Harnett County Government Complex
307 W. Cornelius Harnett Boulevard
Lillington, NC 27546

The plan review for Panaderia La Gloria is approved. A construction walk through was completed today and the following items need repair:

Plan Site

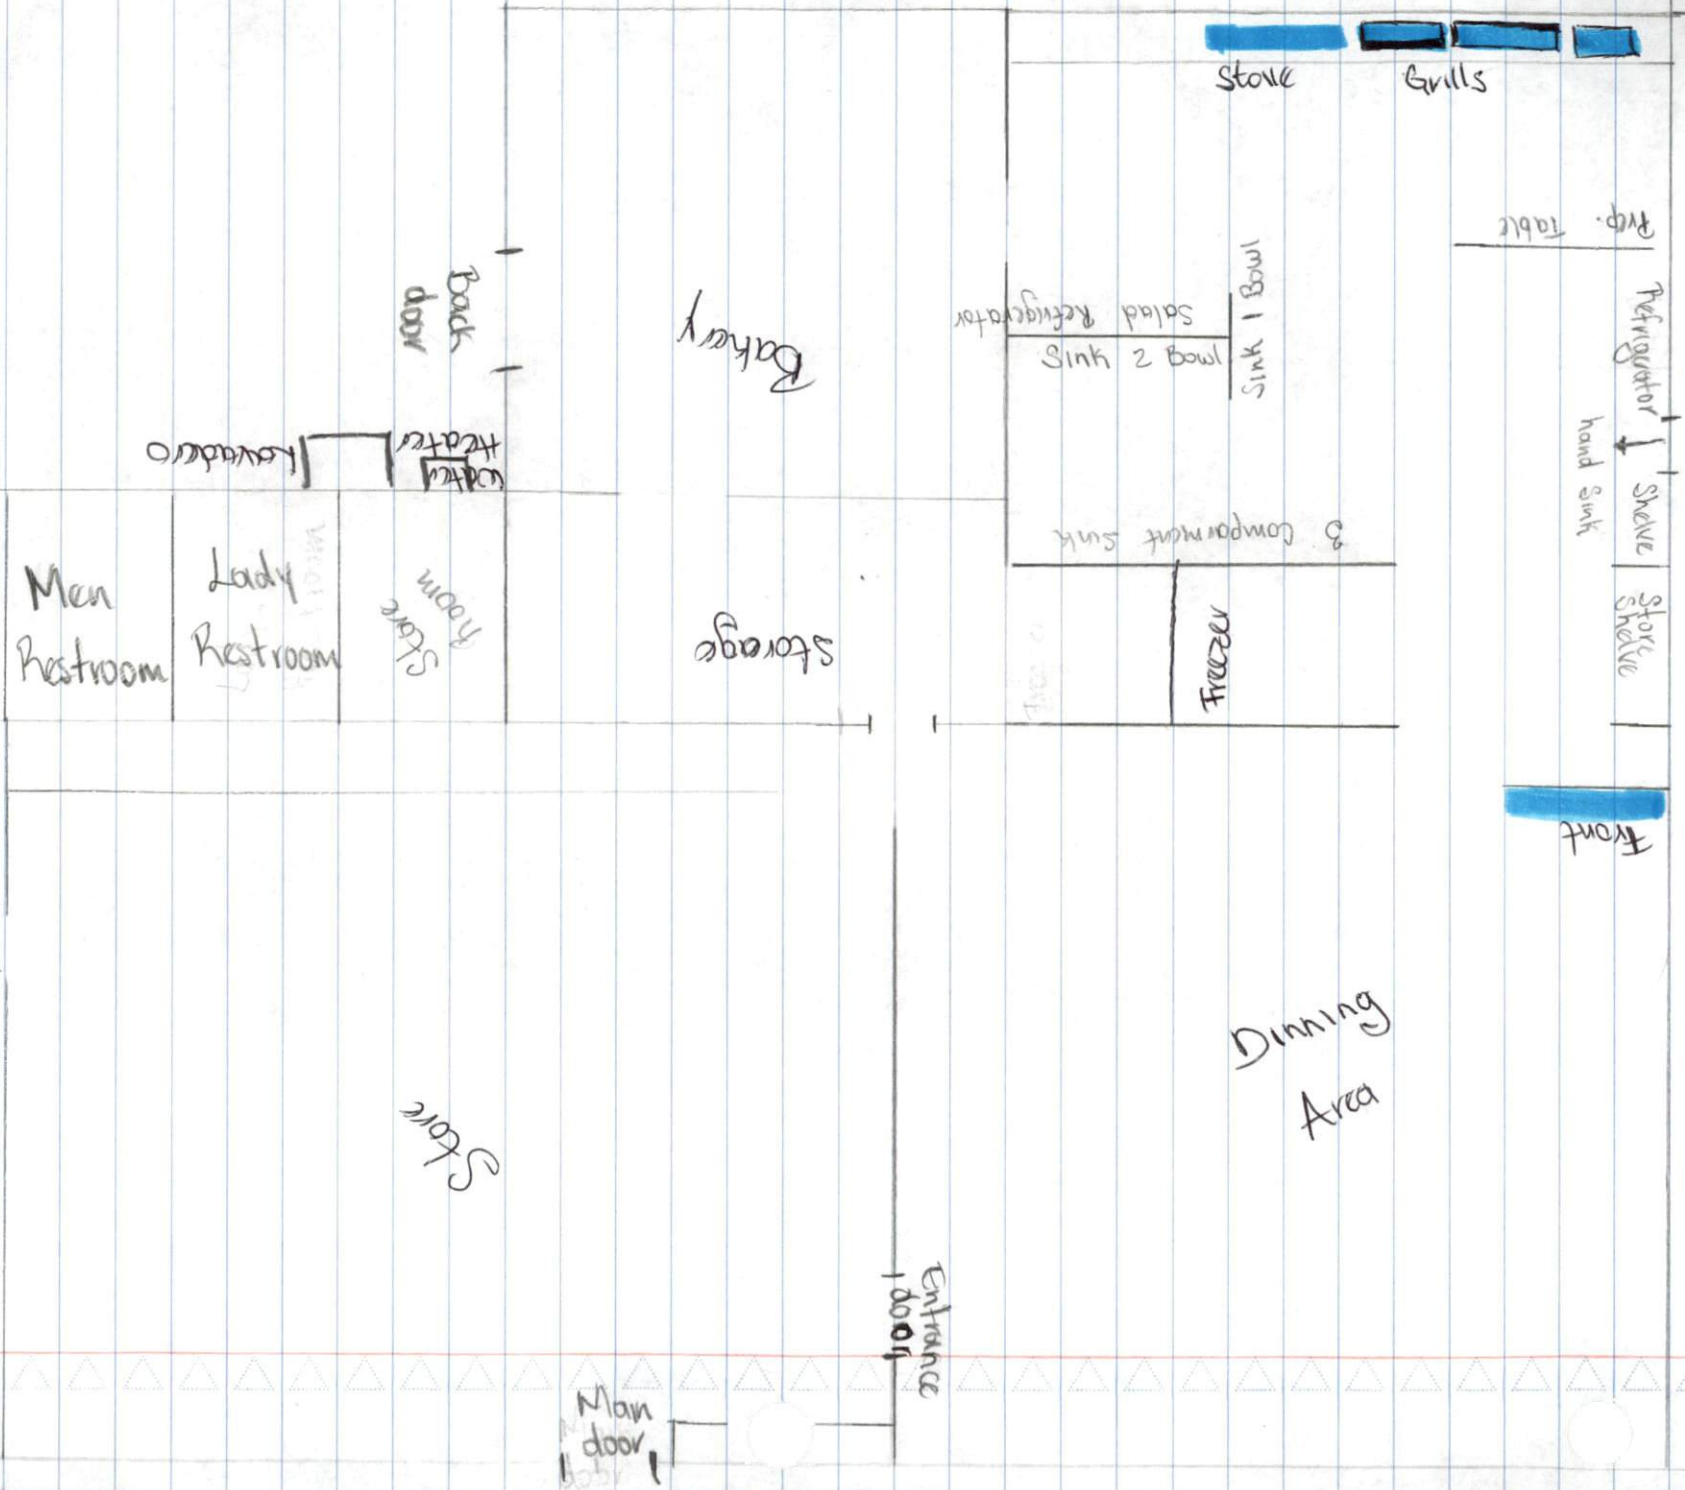
- Repair loose or missing floor tiles.
- Coving loose and gaps present along wall and floor junctures.
- Splashguards needed beside handsink and utensil shelf, beside meat sink and vegetable sink.
- Attach splashguard to wall not the equipment.
- Holes present under two compartment meat sink. Close up hole.
- Gaps present around pipes coming thru wall under dish sink drainboard.
- Provide approved shelving for the storage of dry goods.
- Light shield cracked and to be replaced.
- Ensure all refrigeration is working properly.
- Remove beverage sliding door refrigerator at front counter.
